15 December 2017

# Australian Institute of Architects

# Re. Art Gallery of NSW Expansion Project – Sydney Modern State Significant DA SSD 6471

drawing: Open Space / External Publicly Accessible Areas

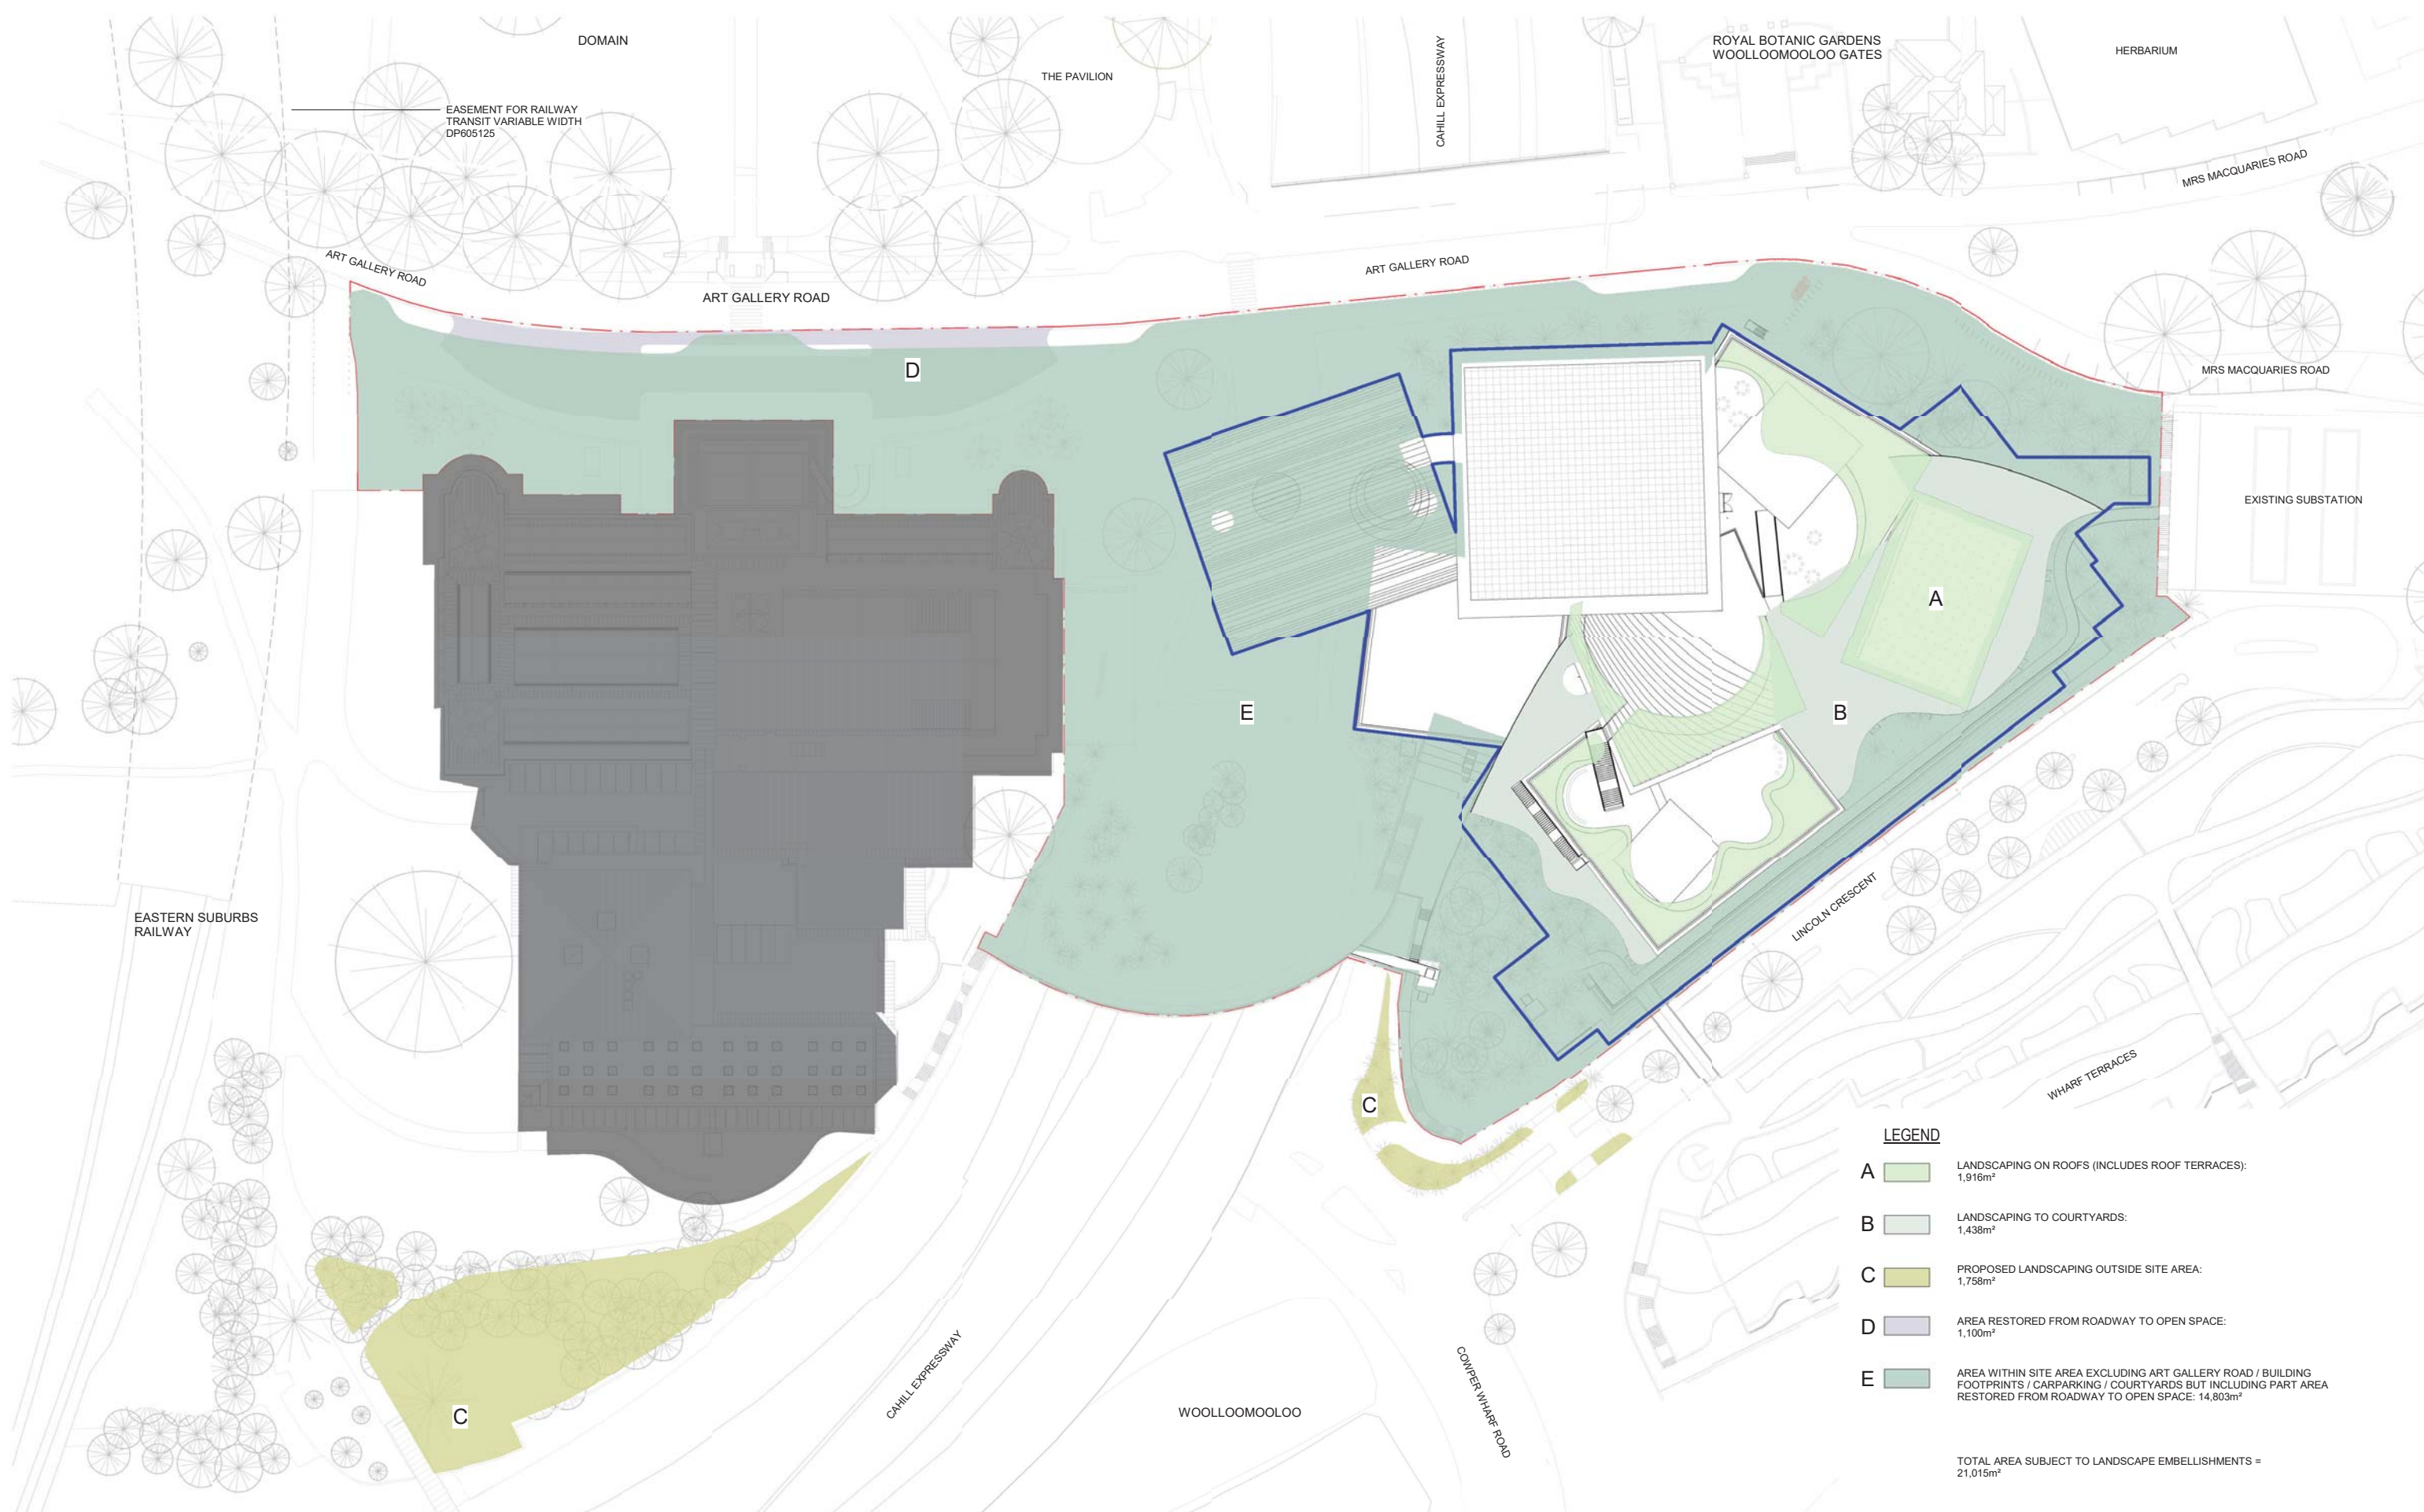
We are pleased to see accessible landscaped roof terraces and the external circulation paths in the project. They seem to deliver on one of the site's best potentials, and will provide a completely unique gallery experience for the public. They must be retained.

**drawing:**  
Proposed Site Plan

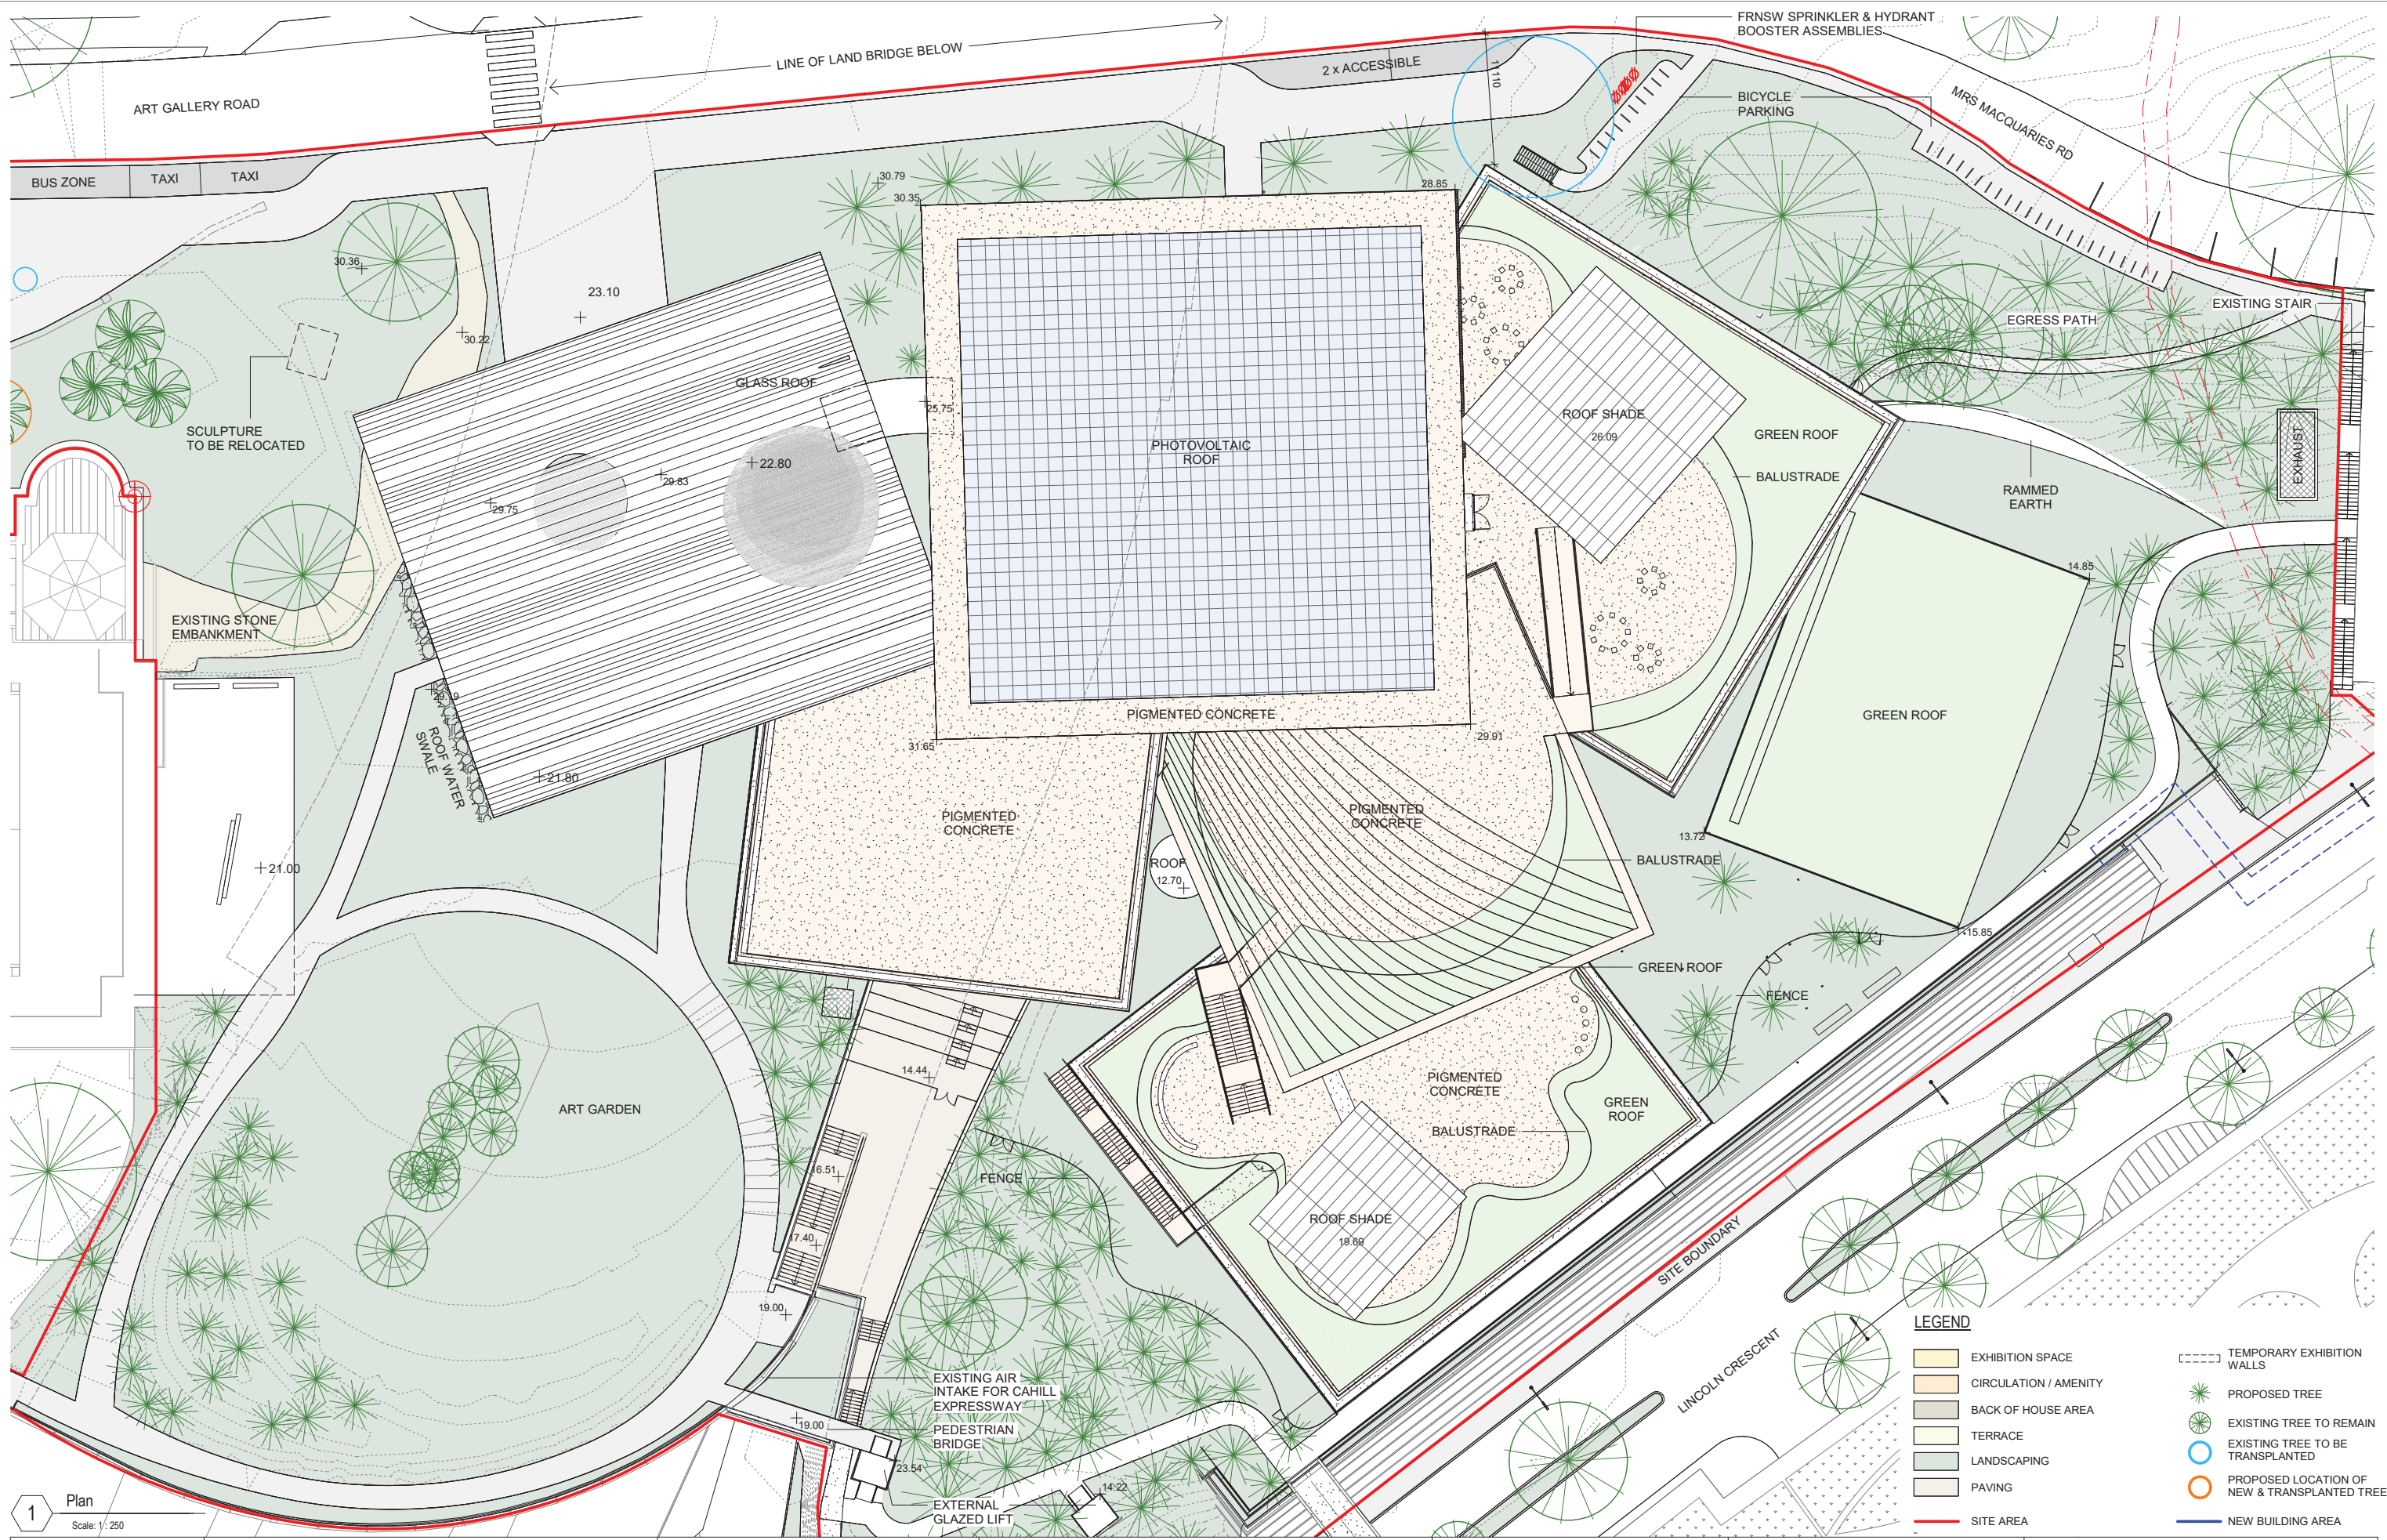
At the time of our previous correspondence on this project, we suggested that this relationship might be strengthened by placing the Sydney Modern entrance closer to the ceremonial entrance to the Royal Botanic Gardens. Whilst the entry has moved, it appears now in an uncertain disposition somewhere between the two. We trust that this will be resolved with greater clarity as the design progresses. In addition, in the current plan, the western edge of the landscape link stops at, and sits off to the east of, Art Gallery Road.

In our previous correspondence with the project we recommended that "serious consideration needs to be given to enhancing Art Gallery Road's traditional role as the ceremonial roadway leading to Mrs Macquarie's Chair. In particular, we recommend that the pavilions facing the road should be pulled back to be in a closer alignment with the Gallery's ceremonial steps; in the current design they will intrude into the visual curtilage of the roadway, which provides a link between the urban form of the city and the parkland environment beyond Sydney modern and the entrance to the Garden".

It appears as though this remains to be addressed.
